AQUIND INTERCONNECTOR

Consultation Report – Appendix 1.7C Marine
Specific – Briefing Note of Meeting with
Natural England 27 June 2019

Natural Power Memorandum			
To	Natural England	Date	July 2019
From	Natural Power	Ref.	1199524

Briefing Note for Ongoing Consultation: Responses to PEIR feedback

TITLE: **FIGURE 1.1 PROPOSED DREDGE DISPOSAL AREA MAP UK DRAWING 1 OF 2**

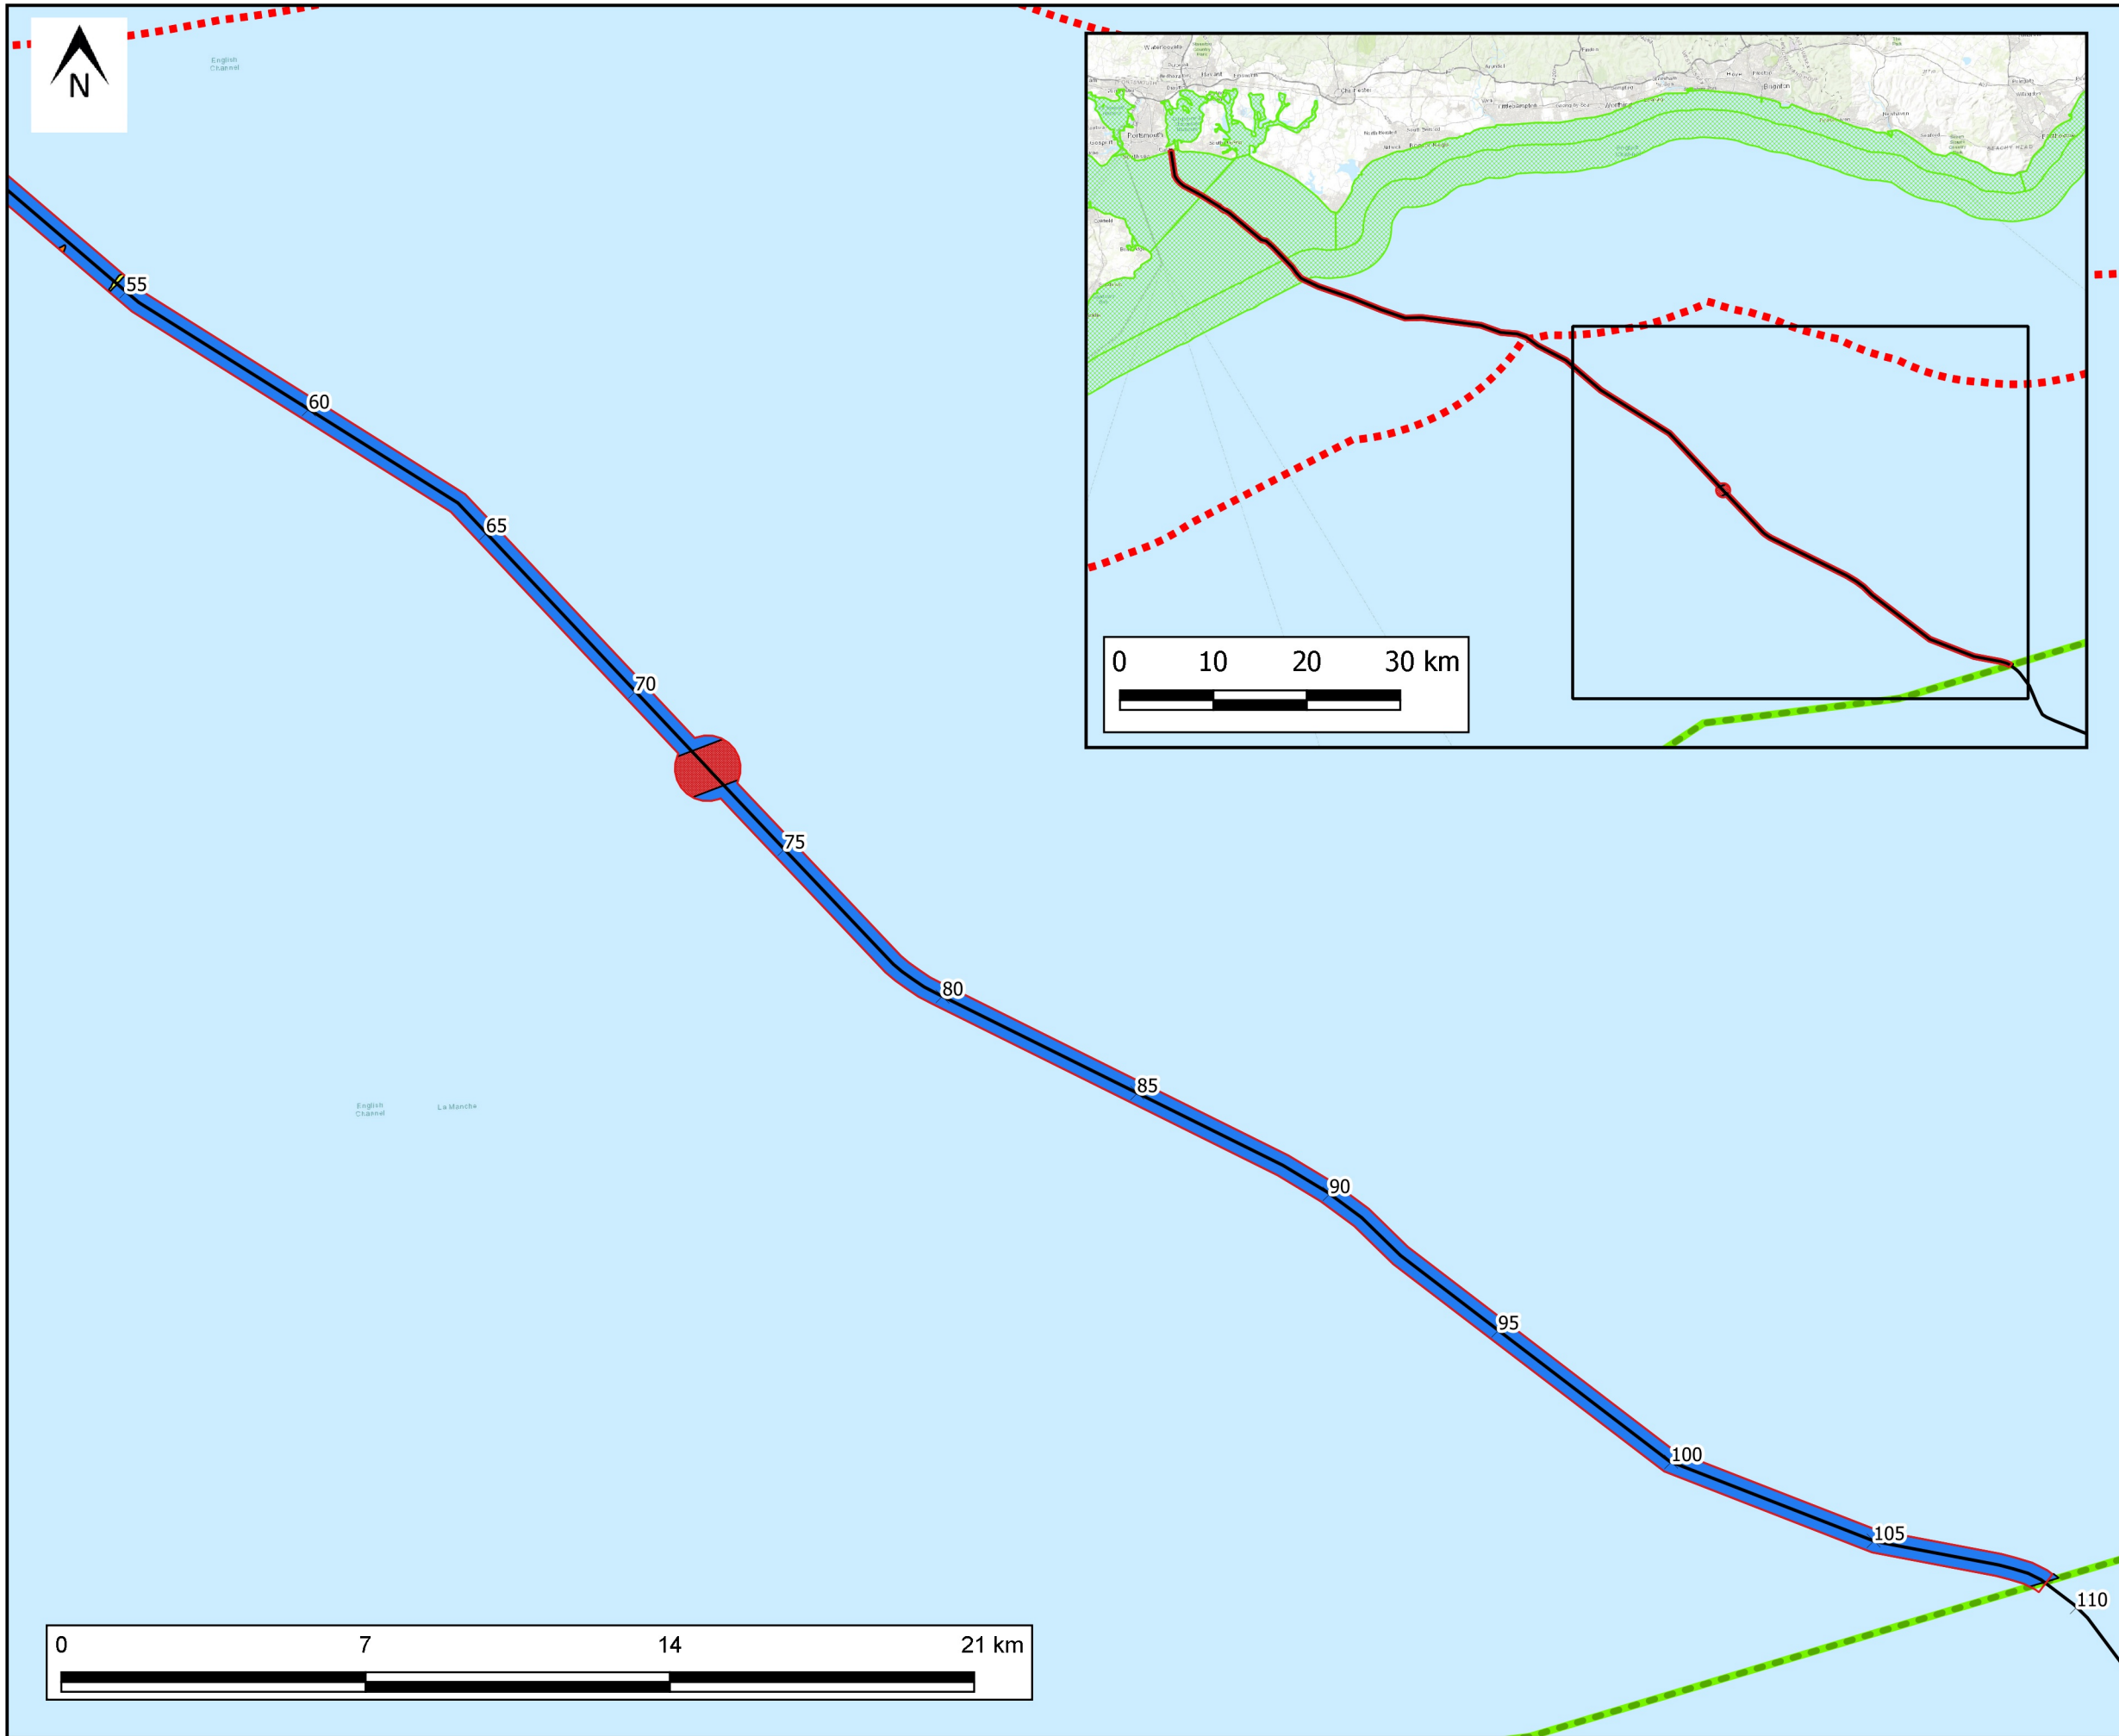
9. NE advised that they were generally content with the approach taken to define the disposal area along the Marine Cable Corridor. NE welcome the commitment to production of a post-consent method statement for dredge and disposal. NE also highlighted that in the assessments it is important to ensure that the worst-case scenarios are captured adequately in relation to designated sites and not only to assessing robustly the potential impacts for disposal but also dredging activity itself.

10. NE main advice is that they request that
 - deposition of dredged material occurs as close to the area of dredging as practicable; and
 - ideally deposition should be upstream of extraction to enable quickest recovery; and
